**SUBJECT: SF-18-025 – Ellicott Town Center Filing No. 1
Response to County PCD-Engineering Review Comments**

In conjunction with our final plat re-submittal, this letter provides responses to the review comments detailed in the Memorandum from PCD-Engineering dated May 26, 2020. These review comments are specifically addressed as follows **(Applicant responses are annotated in bold / red / parenthesis following each County comment):**

PCD Memorandum dated May 26, 2020

SHEET: **TY1**

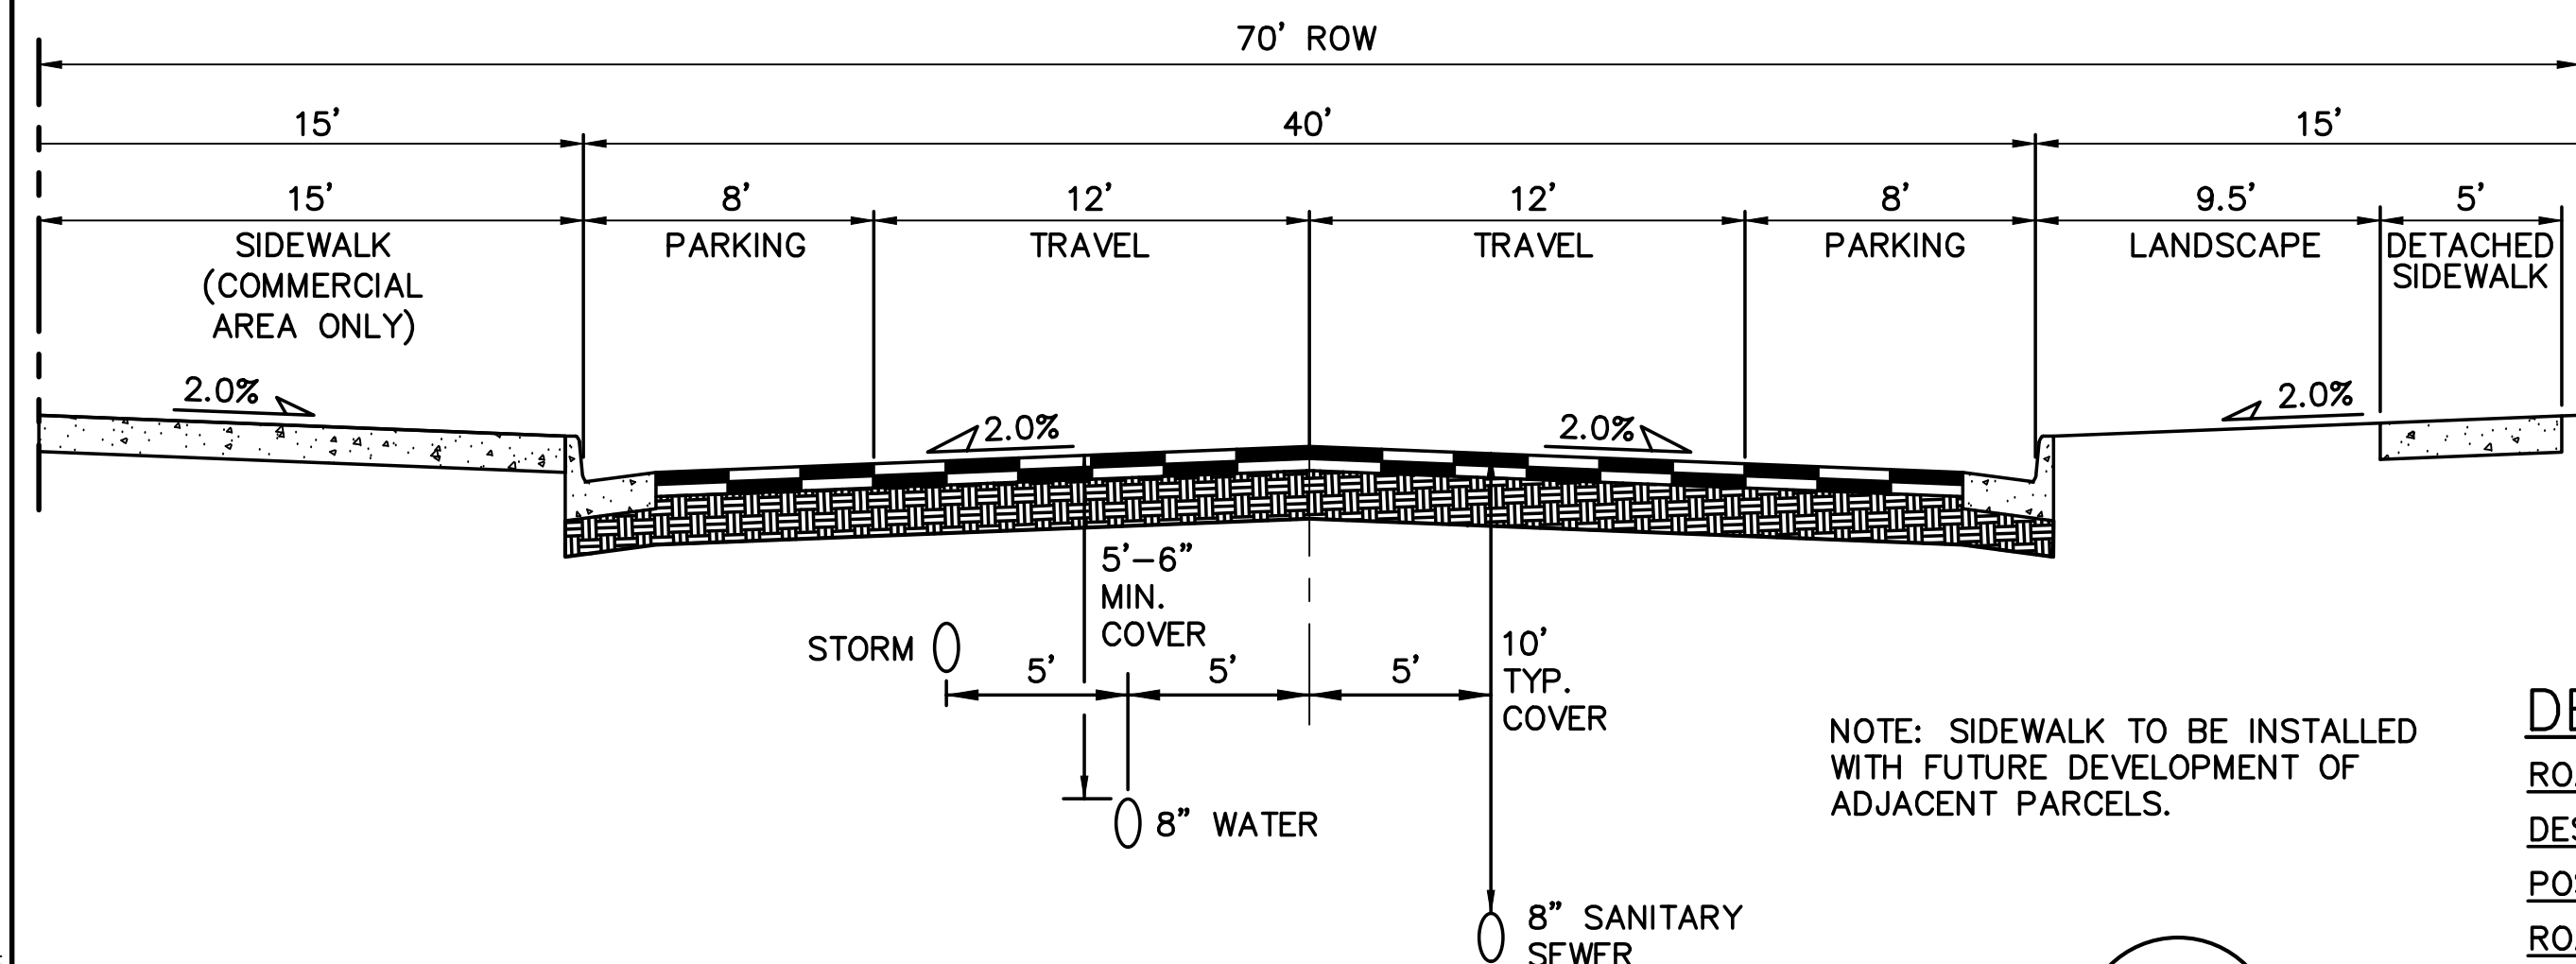
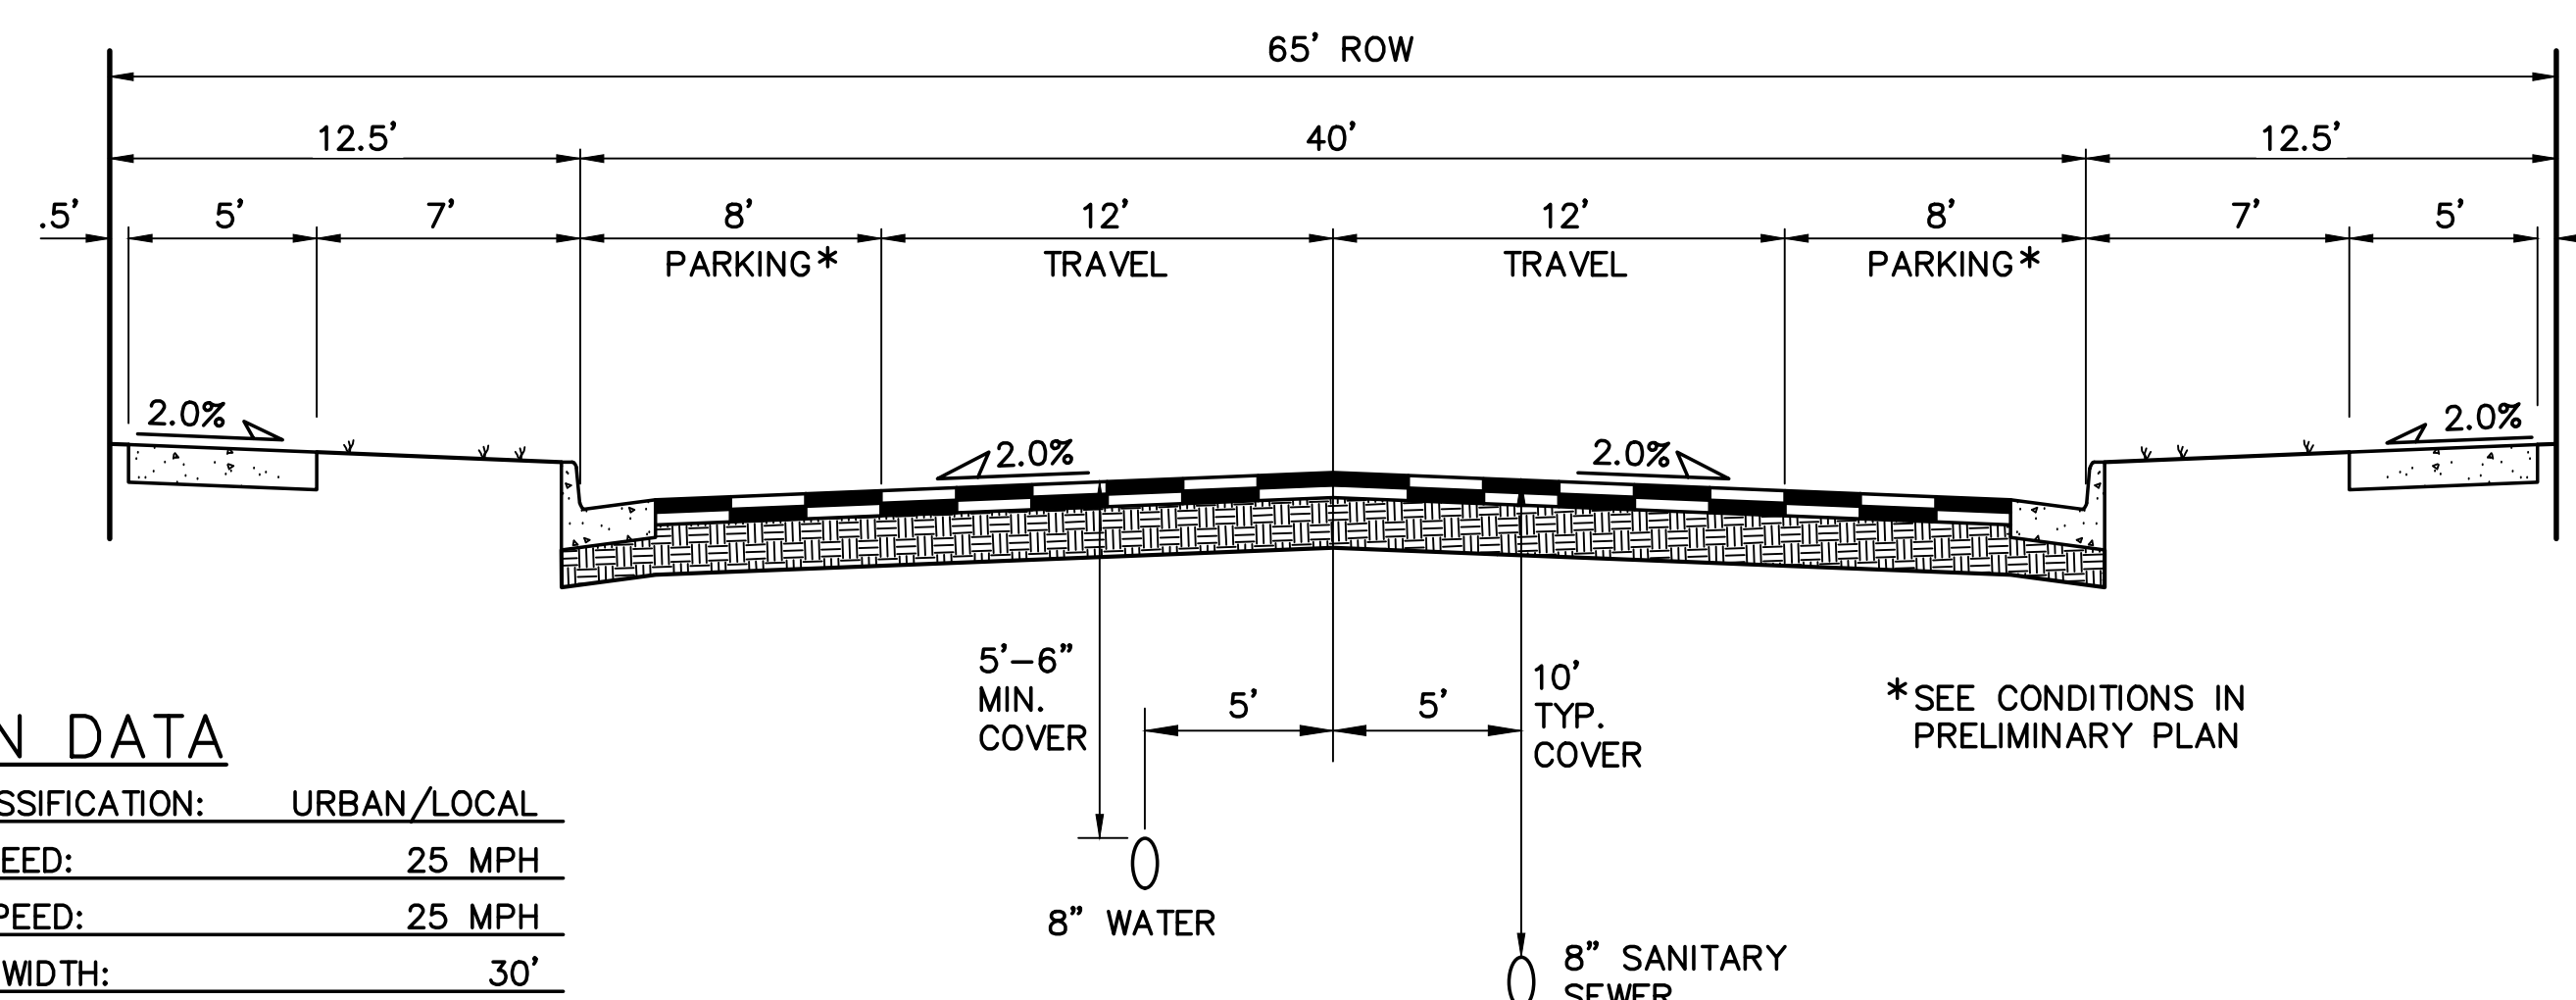
- ii. *Deviation 2 – condition added: The interim gravel segment shall be paved to a 20-foot minimum width, plus 2-foot gravel shoulders, upon traffic counts exceeding 200 ADT. Project conditions of approval will address when traffic counts need to be taken. (Added this note to Springs Road section on Sh. TY1)*

TYPICAL BOULEVARD PHASE 1 INTERIM SECTION (MAYBERRY DRIVE) (C)
(MINOR RESIDENTIAL COLLECTOR)
SCALE: 1"=5' H
1"=2.5' V

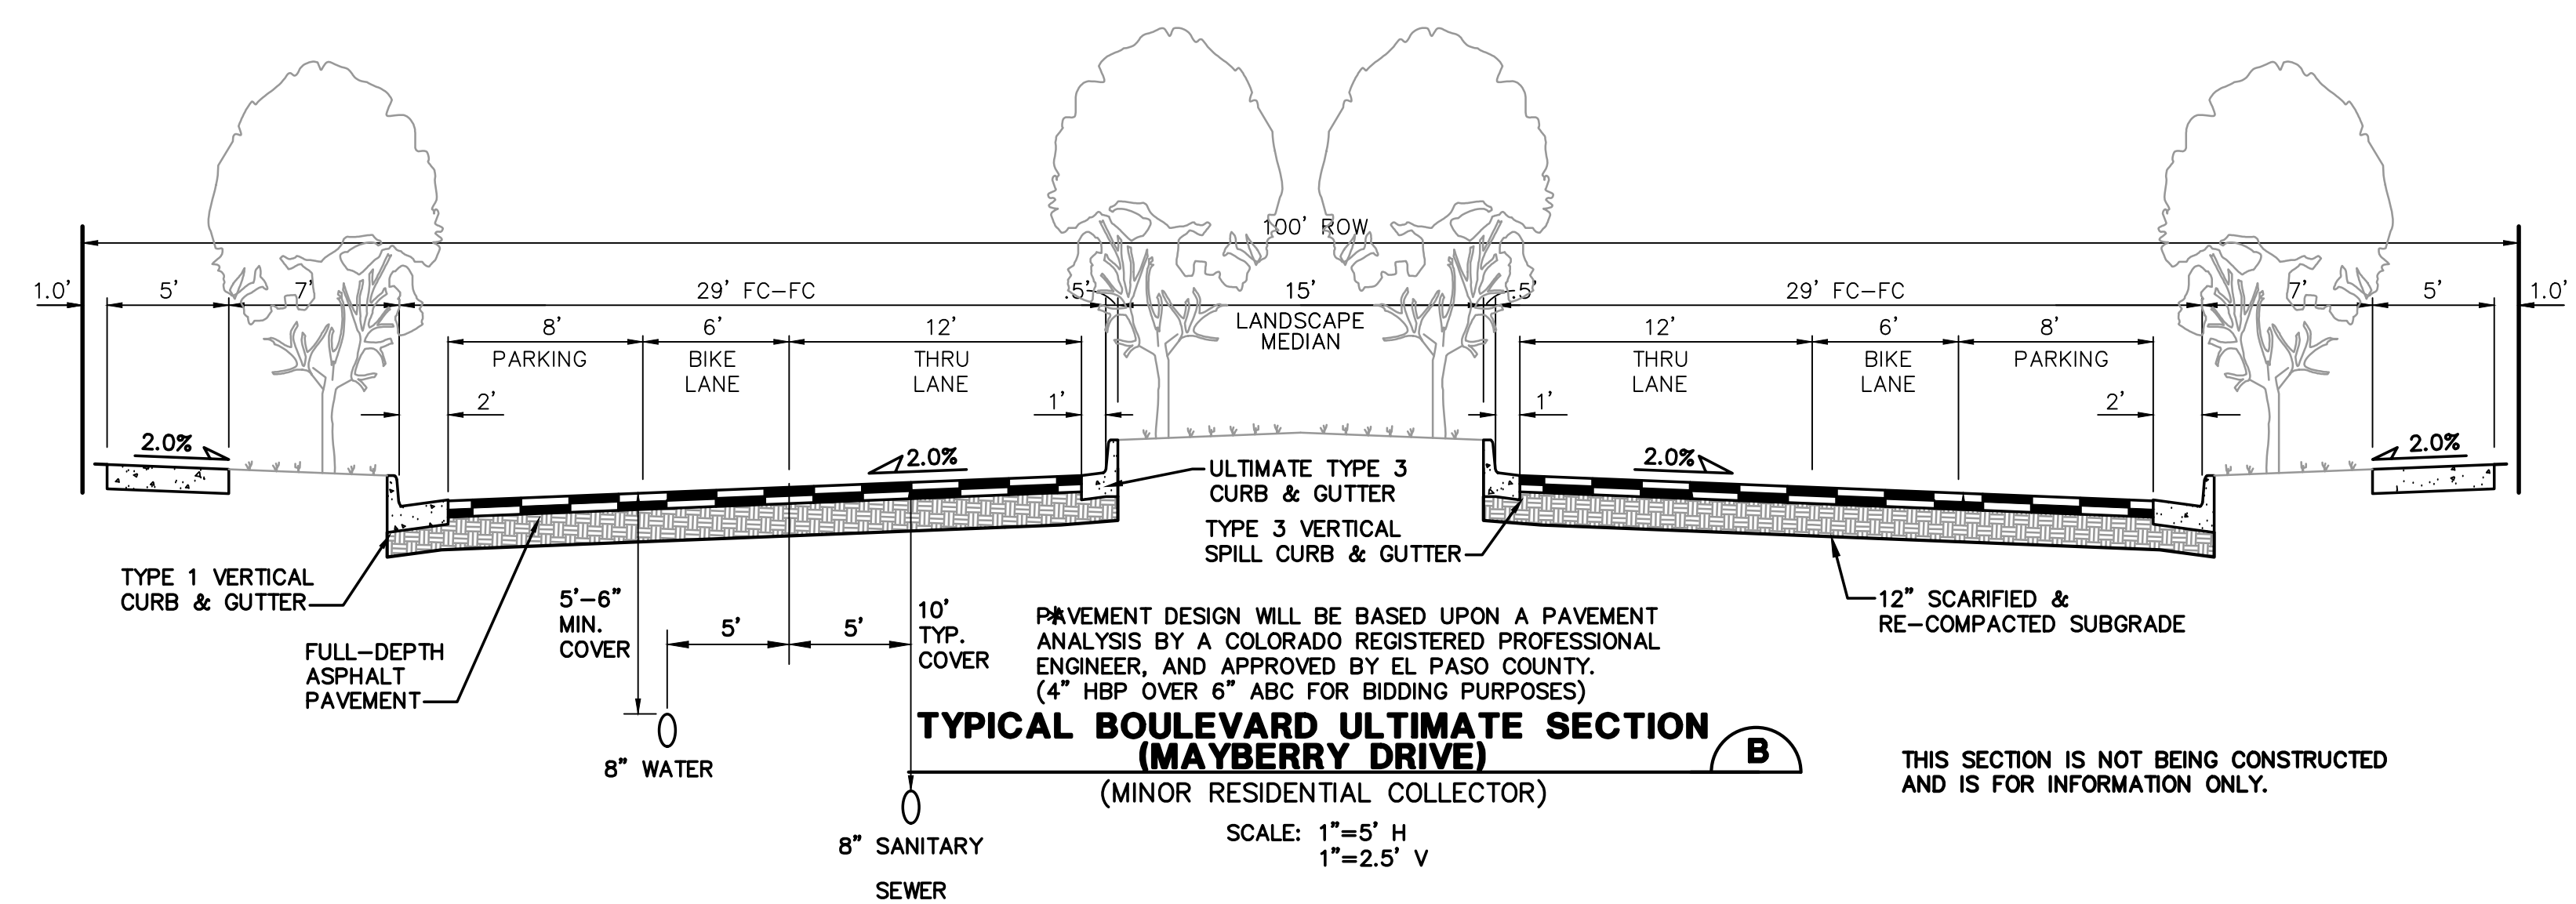
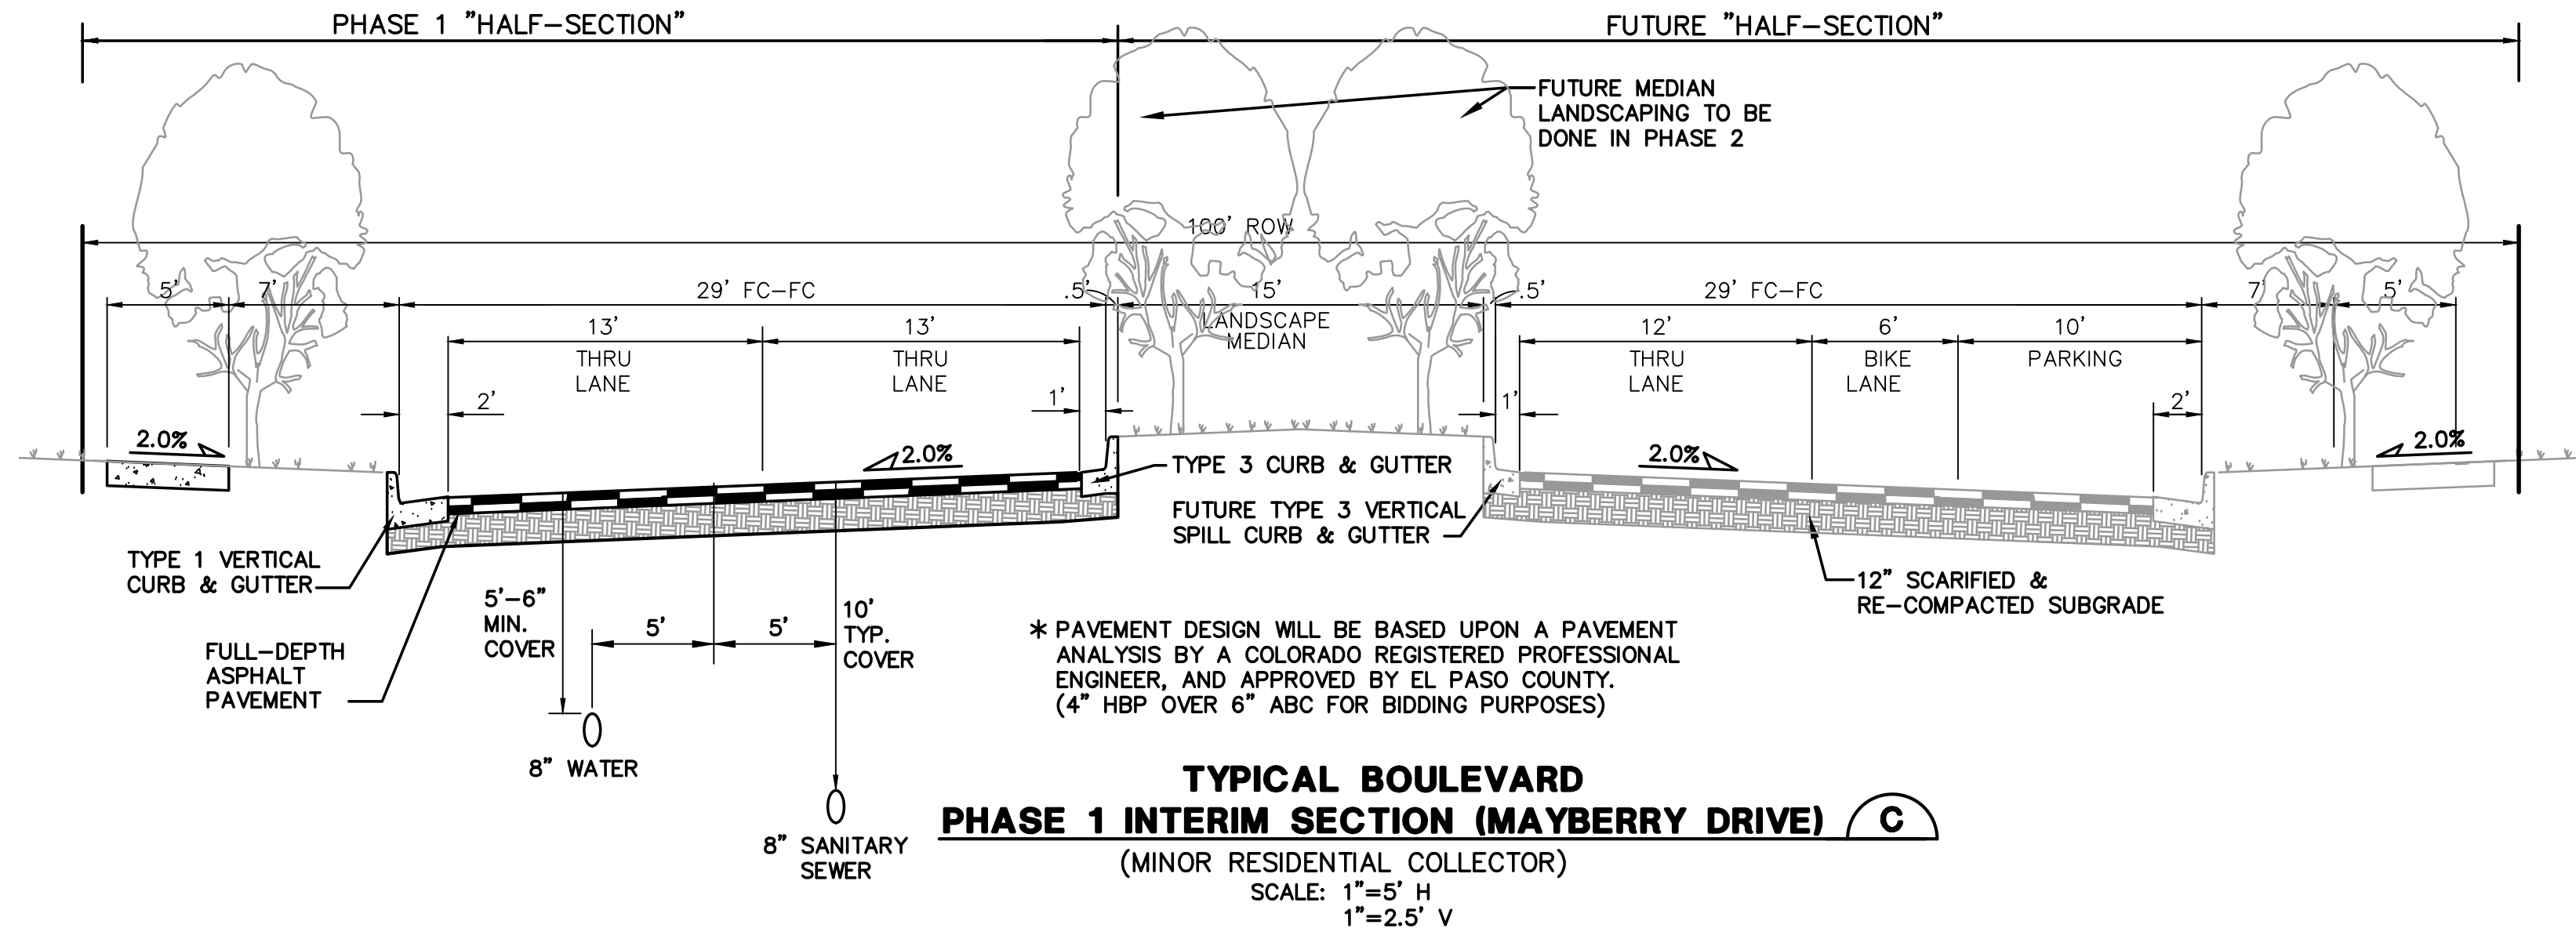
- iii. *Deviation 3 – need additional information on temporary cross/section vs. future width consistency (is the median curb needed or can a shoulder and ditch be used?). The interim width is wider than the ultimate width; will curb and gutter be removed and pavement width narrowed for the full cross-section? (Clarified Interim section of Mayberry Drive on Sh. TY2)*
